**LU/261/18/PL**

The application is the replacement of 4 No. timber windows with PVCu windows of the same design to the north elevation. Whilst the building is relatively modern in design, it is located within the River Road Conservation Area. I note that the windows, whilst constructed in wood, are of a more modern design.

North Elevation (To River Road).

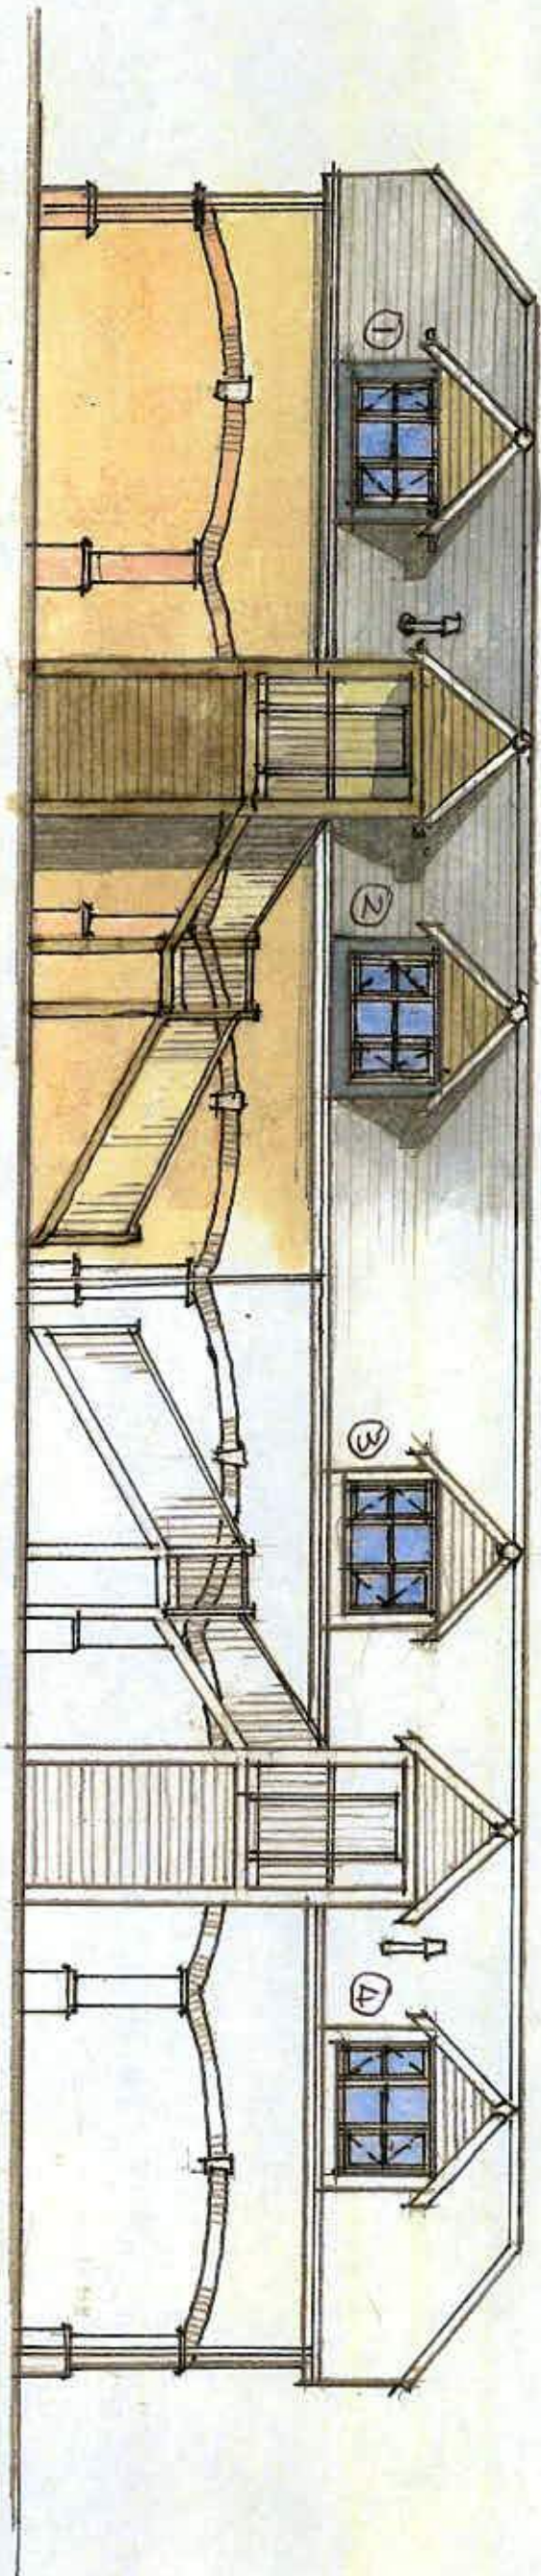
Within conservation areas, the approach is to use traditional materials. I note that the application seeks to replicate the design of the existing windows, but change the material that they are constructed from. In the absence of any details of the proposed windows it is not possible to understand what the impact of the proposal will be. If the proposed windows will appear to look exactly the same, they will have a neutral impact upon the character of the area.
